**APPLICATION BY SEGRO PROPERTIES LIMITED FOR THE EAST MIDLANDS GATEWAY PHASE 2 AND
HIGHWAY ORDER 202X**

Deadline 2 Submission

EAST MIDLANDS INTERNATIONAL AIRPORT LIMITED

4. **AERODROME SAFEGUARDING – COMMUNITY PARK**

Surface Water Bodies

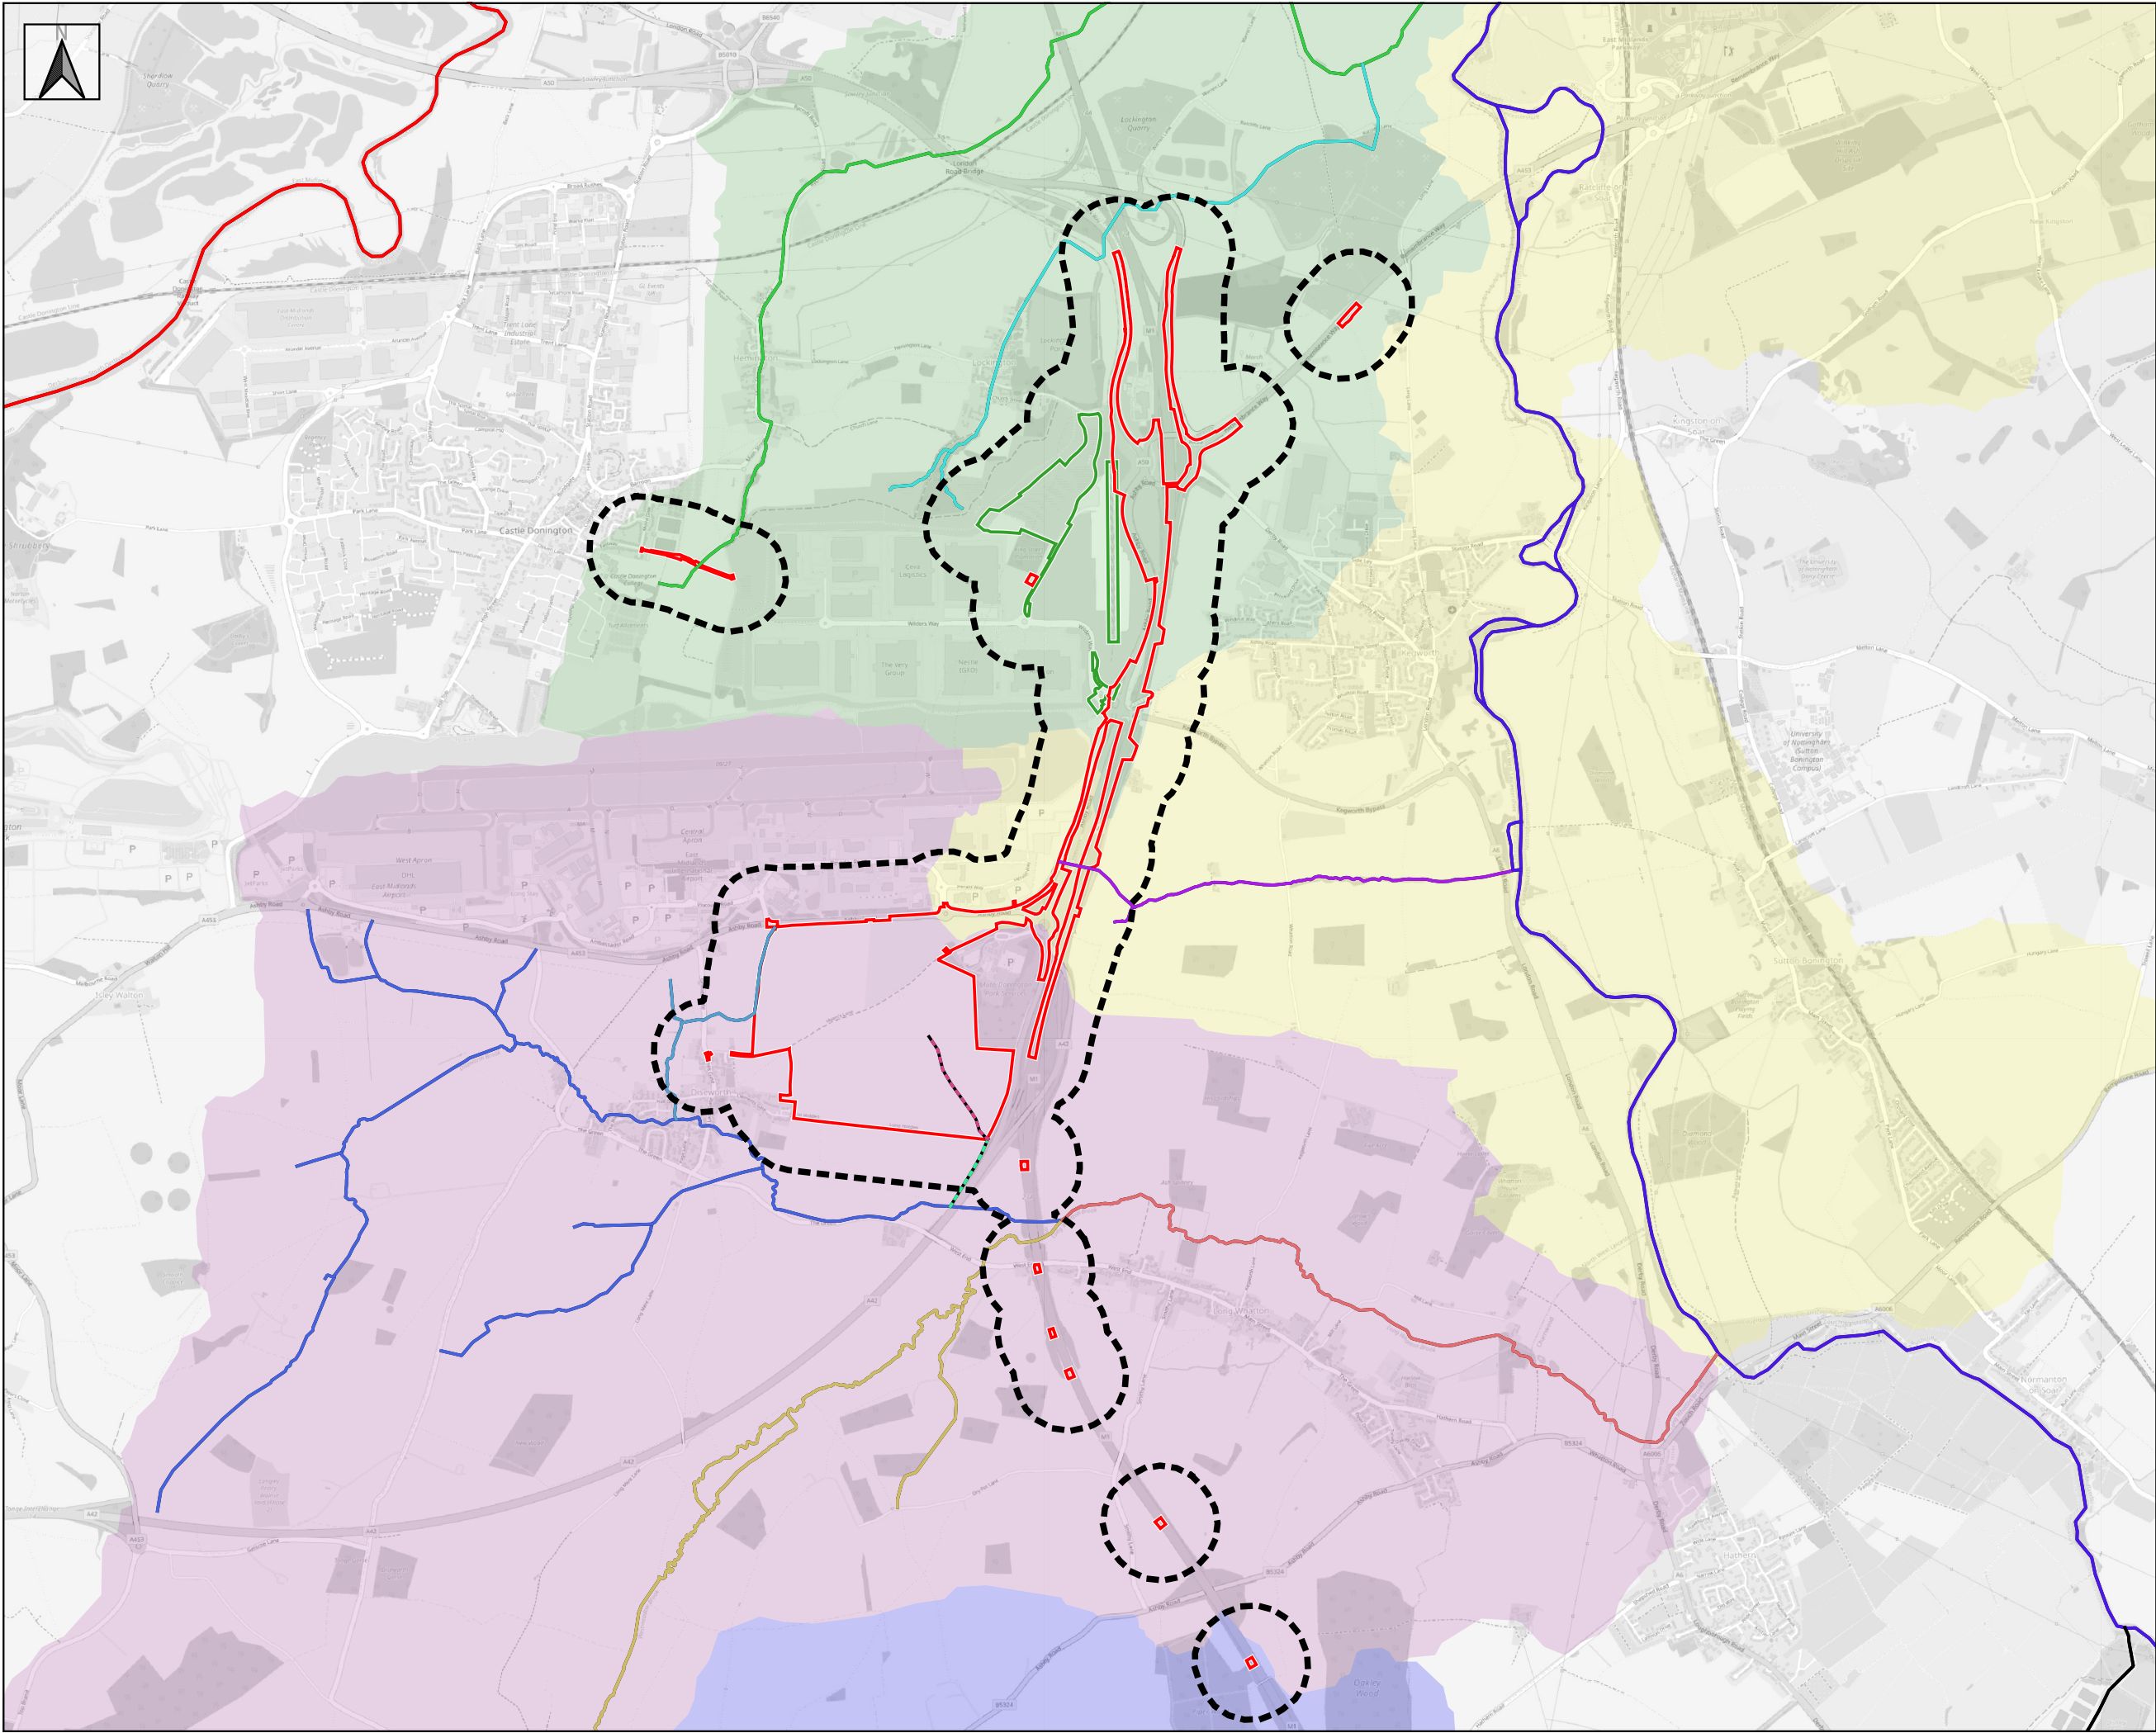
4.3 At the current time, the Applicant has not provided sufficient information about the SuDs to enable EMA to understand and evaluate the full risks with regard to how attractive the attenuation feature will be to birds.

- 4.9 Further information and clarification is sought about the SuDS, specifically on how the corrugations at the base of the attenuation will prevent pooling. A more detailed description of how water will be prevented from pooling is required including the maintenance regime to ensure the water continues to drain.

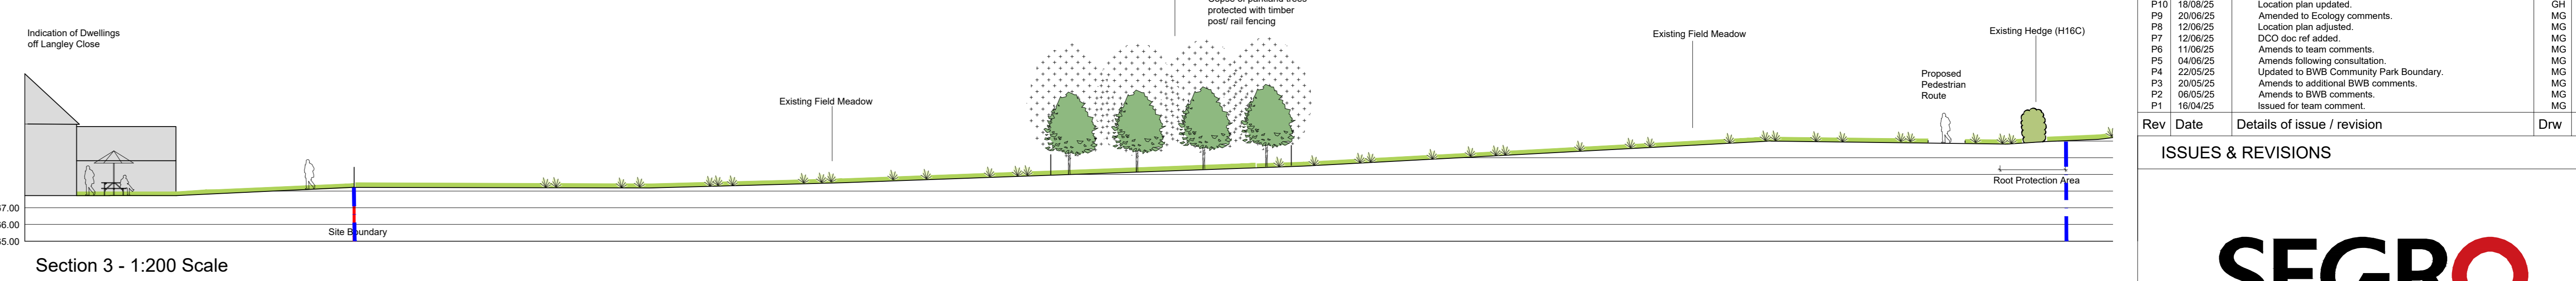
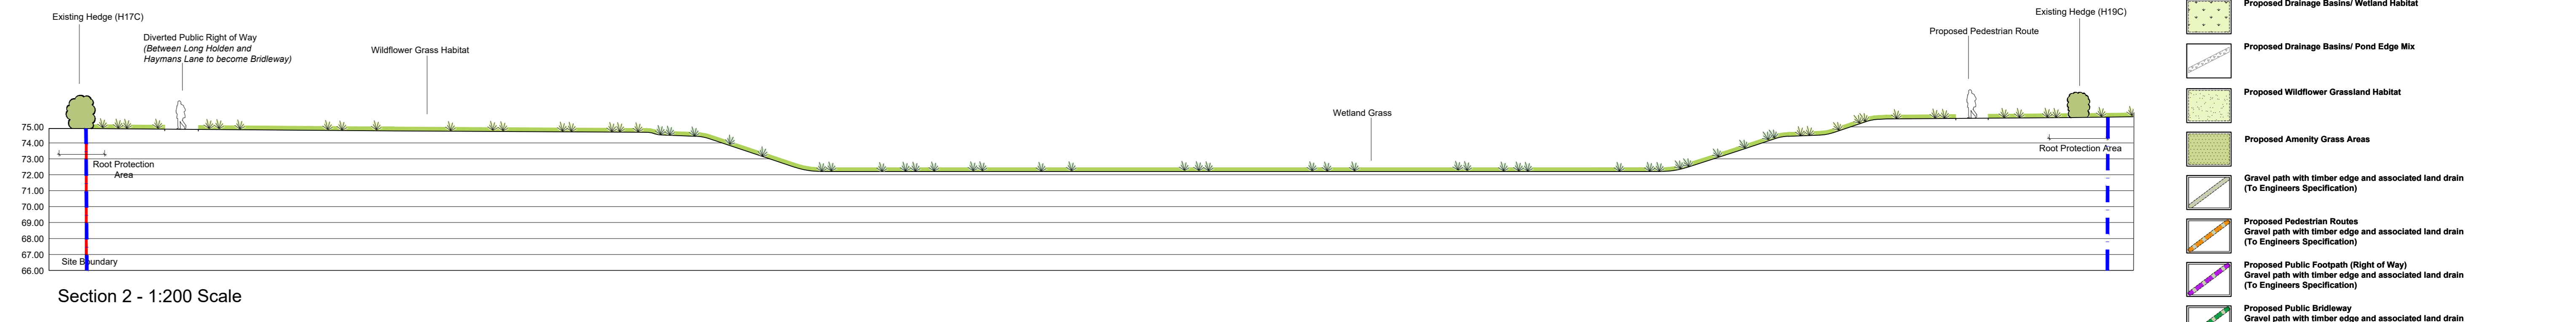
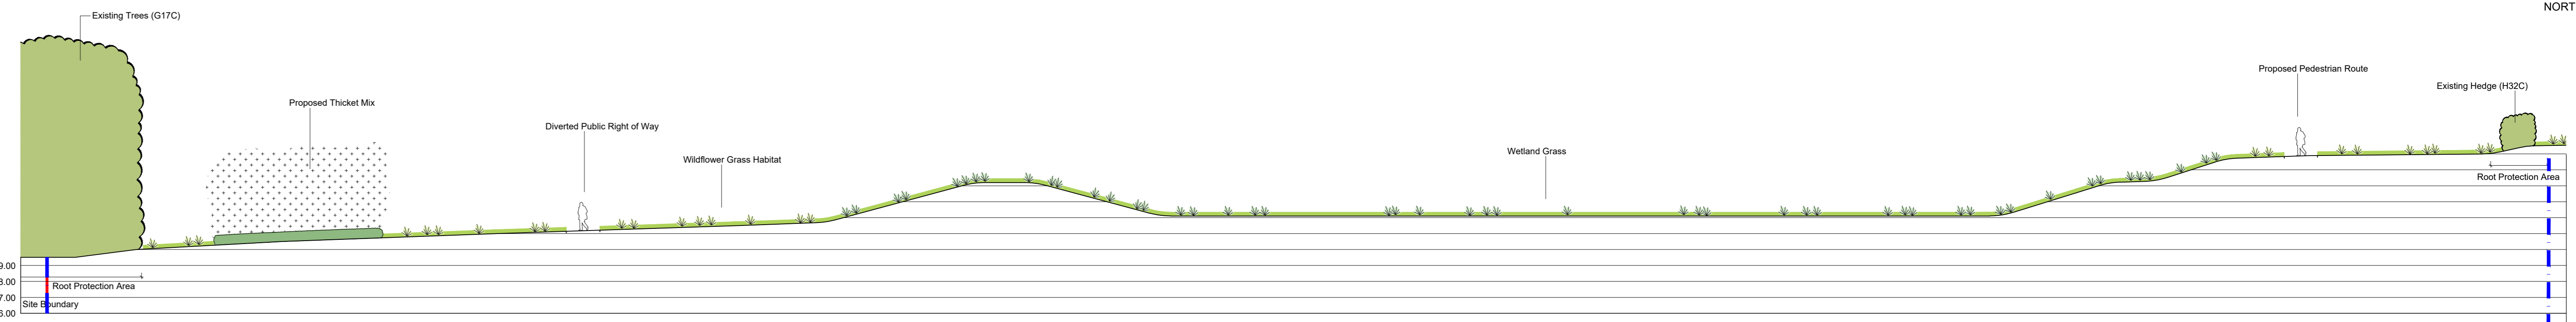
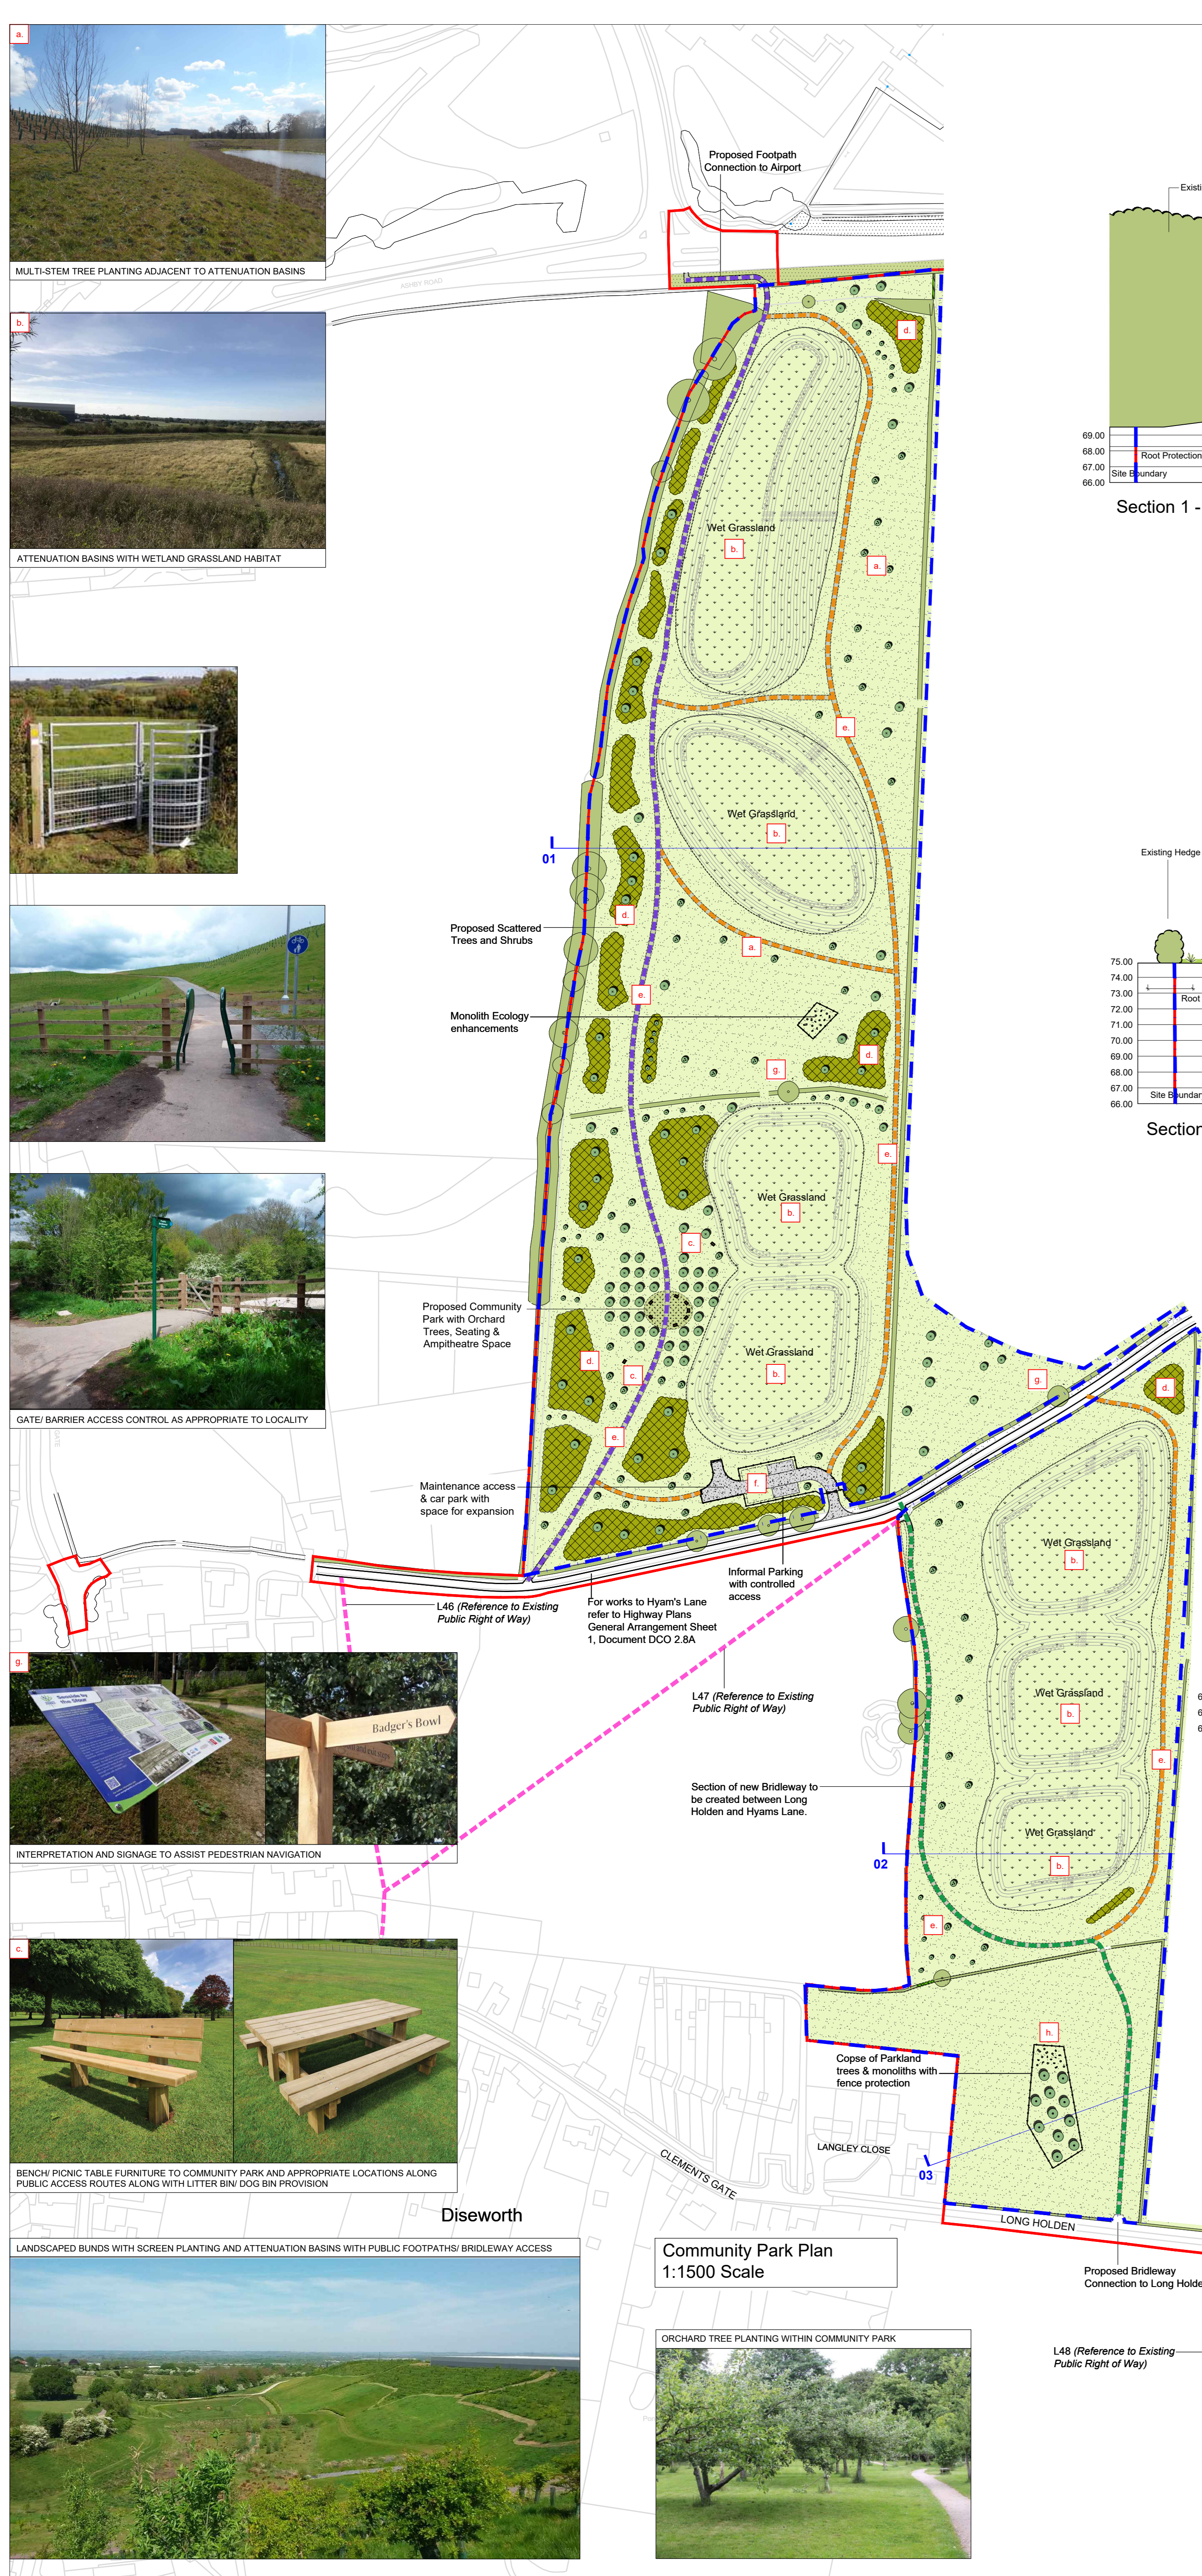
4.4 The principal area of risk concerns the elements of the parkland within the Community Park that could contribute to increasing bird activity. These comprise, but are not limited to:

4.4.2 water bodies (either permanent and/or surface water management); and

4.7 However, given the nature of the proposed community park and the risk profile that such assets can create, it would be strongly preferable to EMA (and it would better inform the ExP) for the Applicant to improve the clarity of design of the parkland and provide updated versions of the following documents:

4.7.1 APP-058D DCO 2.16 Community Park Plan;
